Householder Proforma

Application Ref: 2021/0760
Address: 15 Baslow Crescent
Neighbour Representations: No
Consultations None
Property Description: the detached bungalow is located in a purely residential area, the area is characterised by a mix of single storey, standard two storey and dormer bungalows. The dwelling is located in a corner plot at the junction of Baslow Crescent and Haddon Close
Proposed Extension: erection of a single storey side extension and the erection of a detached garage
UDP Designation: Housing Policy Area
Local Plan Designation: Urban Fabric
Conservation Area: No
Relevant History: N/A
Acceptable in Principle: Yes

PLANS & ELEVATIONS

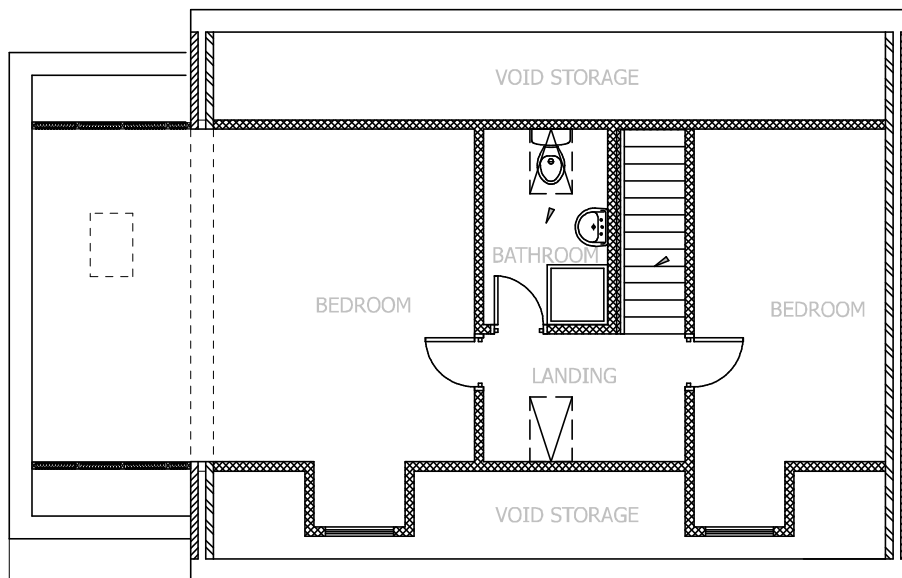
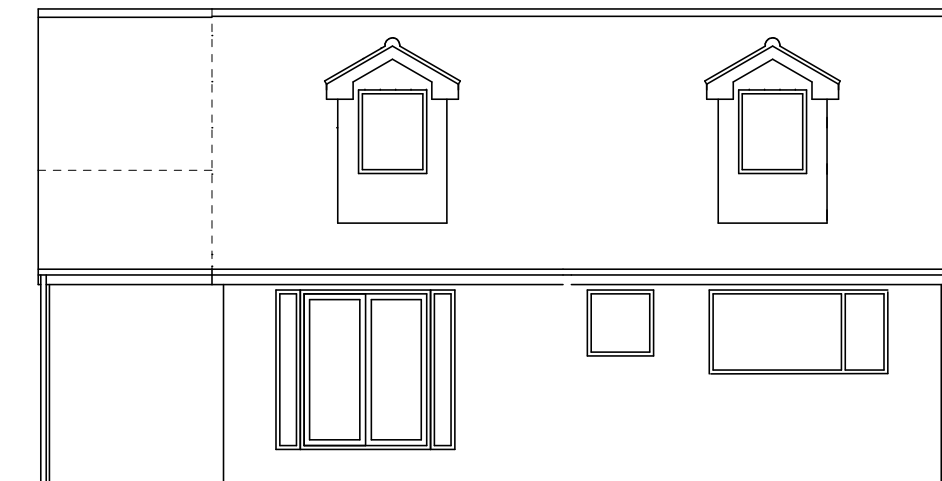
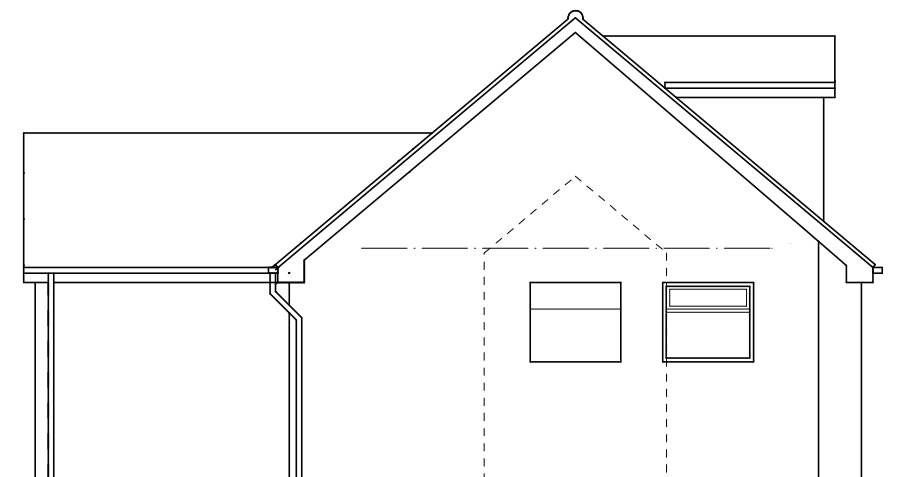
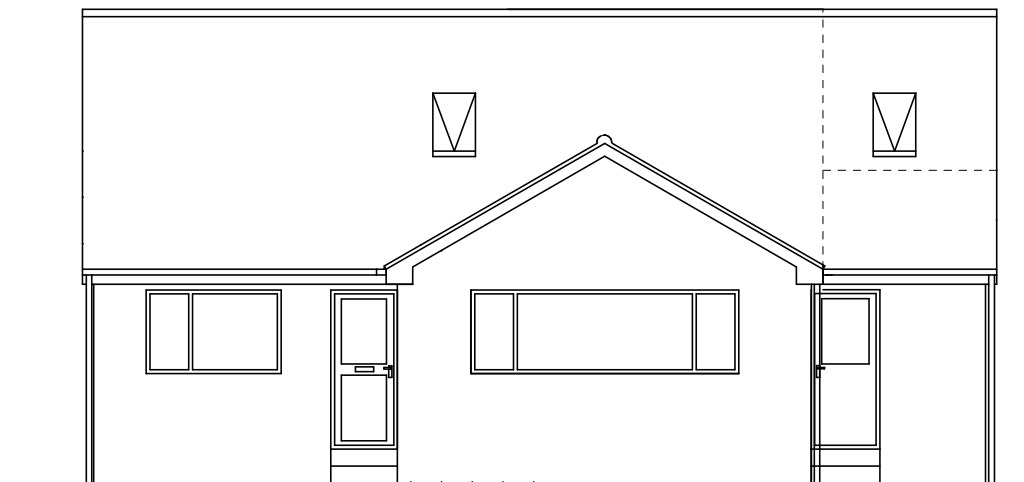
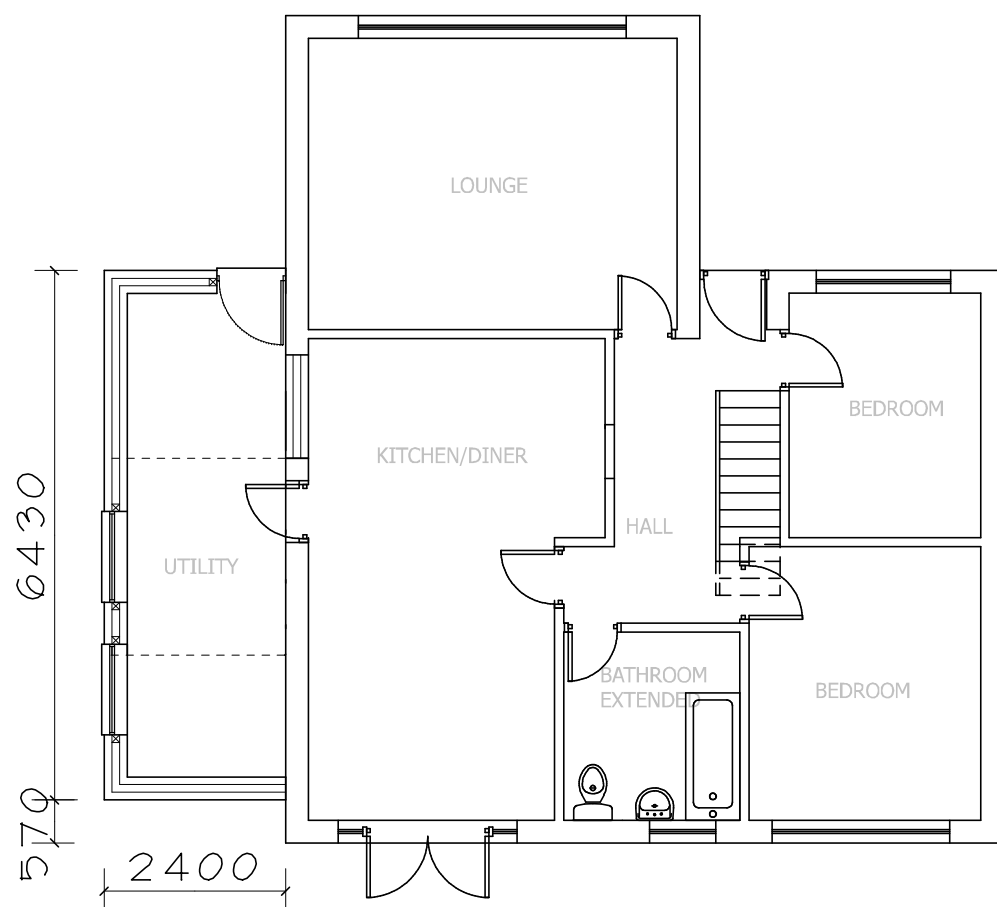
the proposed extension is to be located on the northern side elevation adjacent to Haddon Close, the extension does not have a width greater than 2/3 width of the original dwelling and a gap of 2.4m is retained from the side elevation of the proposed extension to the boundary with the highway.

The proposal does not include a set back, however in this instance is it considered acceptable as the existing forward gable projection will provide a vertical break avoiding the unsightly bonding of old and new materials within the dwelling. It is clear following the site visit that the dwelling has recently undergone some maintenance works, include the installation of a new roof covering, therefore there wouldn't be an issue with the bonding of old and new materials within the roof.

It is acknowledged that the ridge of the proposed extension is not set down from the original, however, given that the roof space it utilised for living accommodation the reduction in ridge would limit the use of the space.

It is not considered that the lack of set back and corresponding lowering of the ridge would have an impact on the character of the street given the dwelling's location within a corner plot and that it is surrounded by two storey properties and dormer bungalows to the north and west respectively, and whilst the dwelling is in a row of bungalows it forms a 'book end' in this location.

The roof design corresponds to the existing dwelling, with the windows and doors of a similar design and proportion to the original.

There are windows located on the side elevation, however this will not increase levels of overlooking given that the dwelling is located in a corner plot and would overlook the highway, with a suitable separation between the neighbouring property.

PROPOSED GARAGE

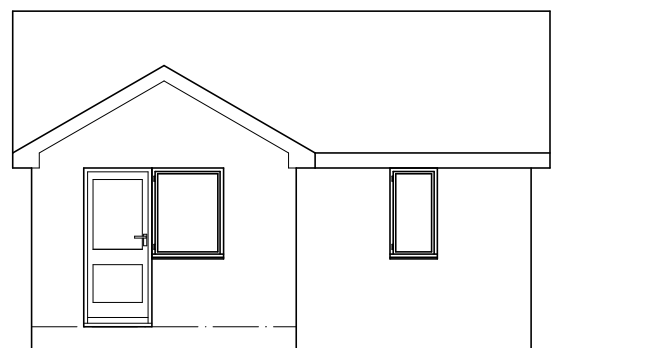
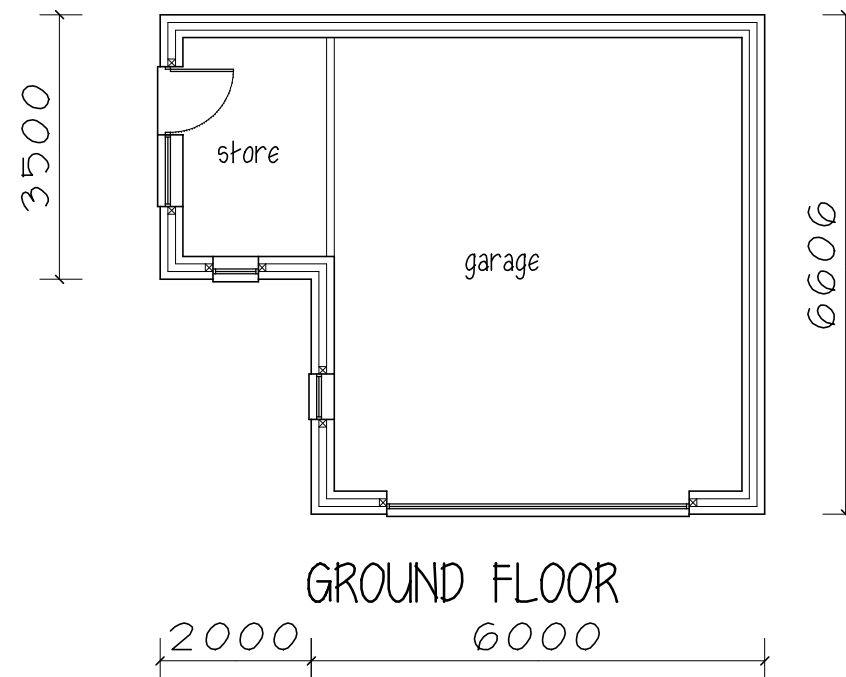
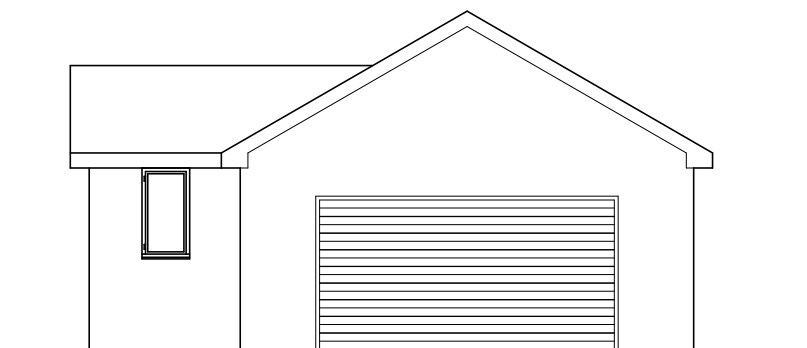
The detached garage is to be located within the rear garden of the property, adjacent to the southern boundary with 1 Haddon Close.

The dwelling is single storey with a height to the eaves of 2.5m and 4.4m to the ridge.

It is to measure 6m by 6.6m, a standard size for a detached double garage, with a small 3.5m by 2m off shot as a store area.

The size and design is sympathetic to the original dwelling and is not considered out of character with the area or comparable in footprint to a separate detached dwelling.

It is acknowledged that the dwelling is located adjacent to the boundary with 1 Haddon Close, however the garage replaces an existing garage and it is designed with a low eaves level with the roof sloping away from the boundary.

The location of the garage maintains a driveways length of a minimum of 6m allowing a vehicle to exit the highway in order to enter the garage.
